Subject: RE: Y/65/22/DOC - Bonhams Field (Plots 2 and 3 Only).

Whilst writing, I have today had comments from our engineer re Y/76/22/PL:

TITLE: Proposed Drainage and Levels Layout Plan
Phase 1 - Whole Site

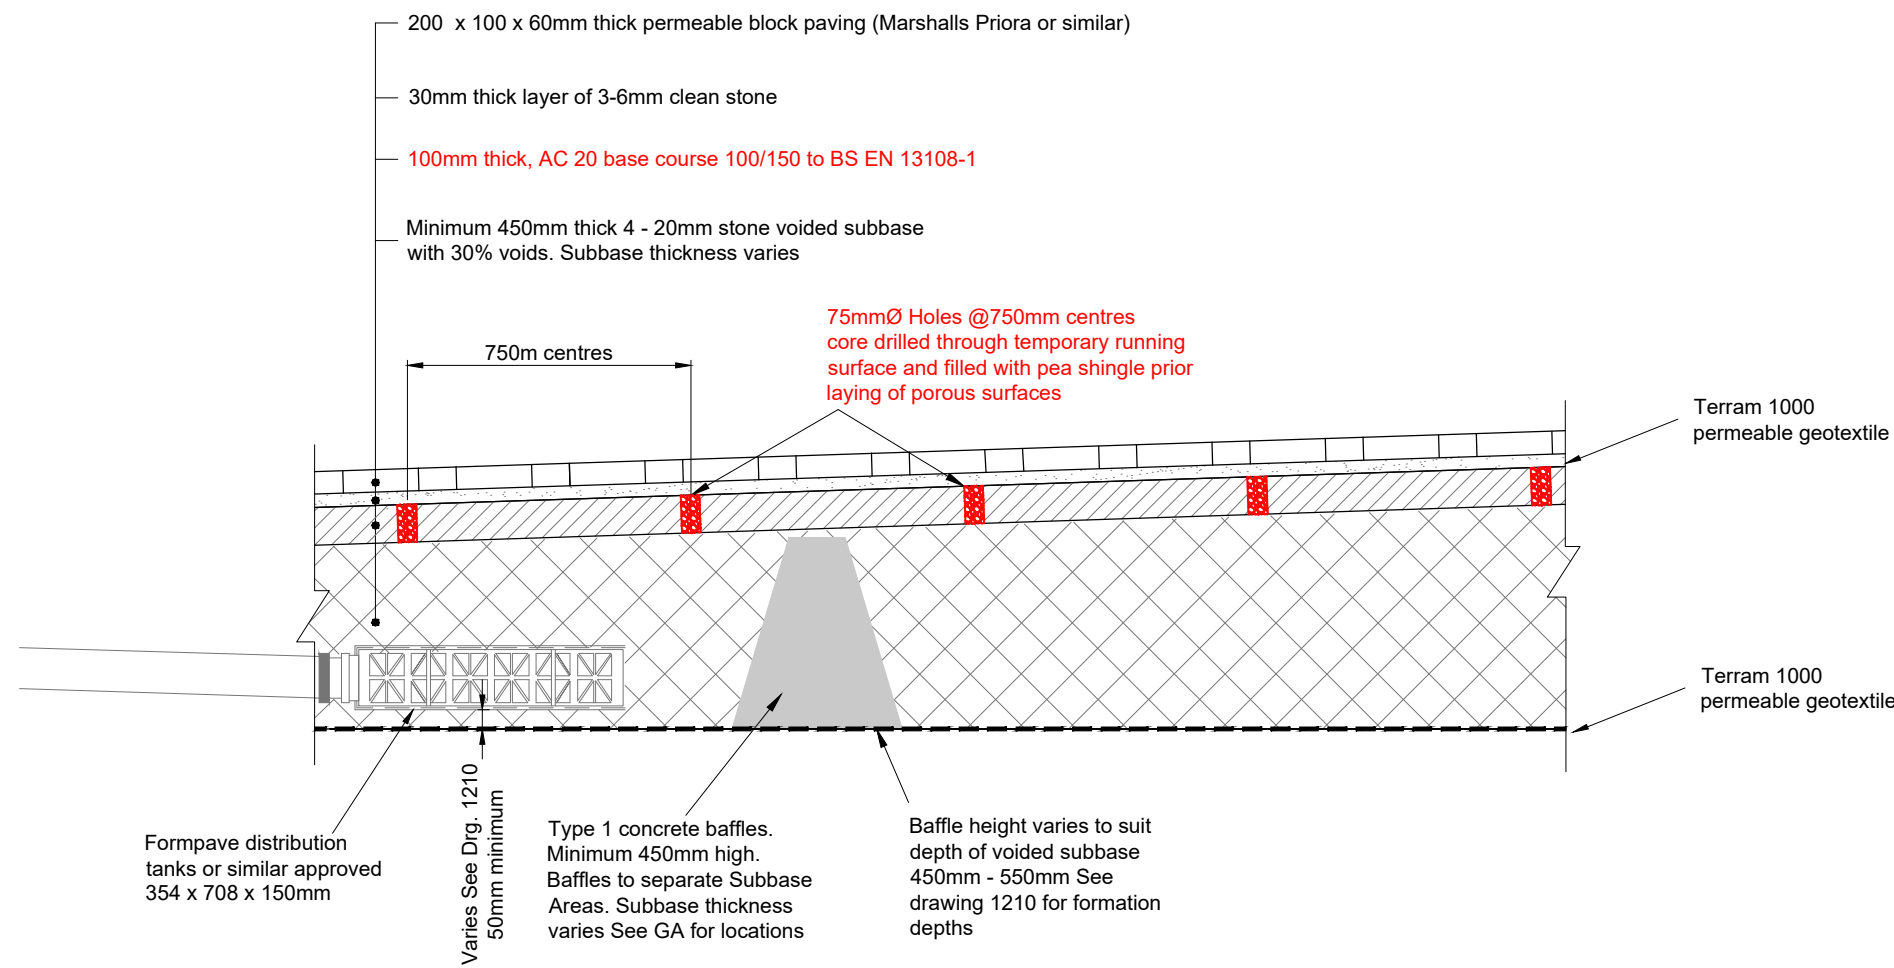
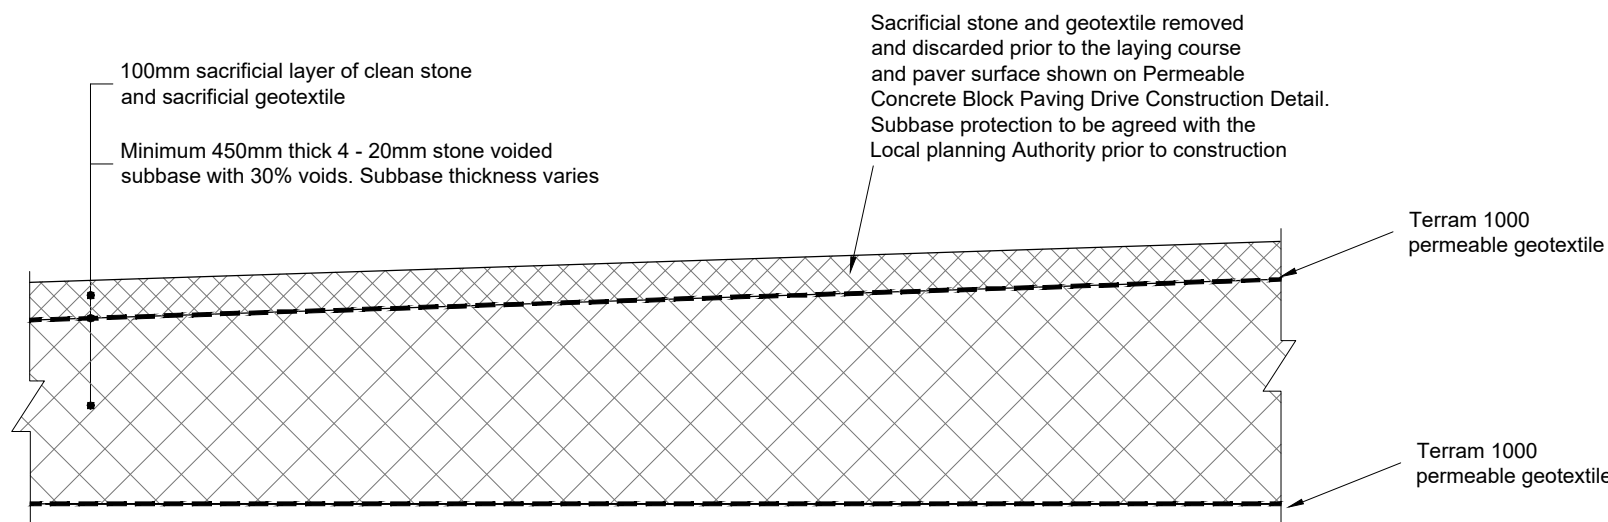
"It is noted that this site has an approved surface water drainage design, 1210K Site Layout Proposed Drainage Plan under planning application reference Y/47/21/DOC. The addition of three visitor car parking spaces is not shown on this design. The Sales Plan that is provided with this application indicates that the car parking will be 'S3 Vehicular block paving to parking areas contrast colour', this would imply a more permanent change to the layout of the site. If the car parking spaces were to be self-drained gravel or permeable block paving then we would have no objection to the addition. However, with the risk of the block paving becoming permanent we will either need to see an alteration made to the surface water drainage design for the site (a new DOC application) or the surfacing adjusted to an entirely self-draining material, in which case I would expect a condition to be imposed to ensure that the surfacing is removed. I also note that the site has a surface water drainage verification condition applied to the approval (Condition 13 on application ref Y/1/17/OUT). This must be discharged prior to occupation of the plot."
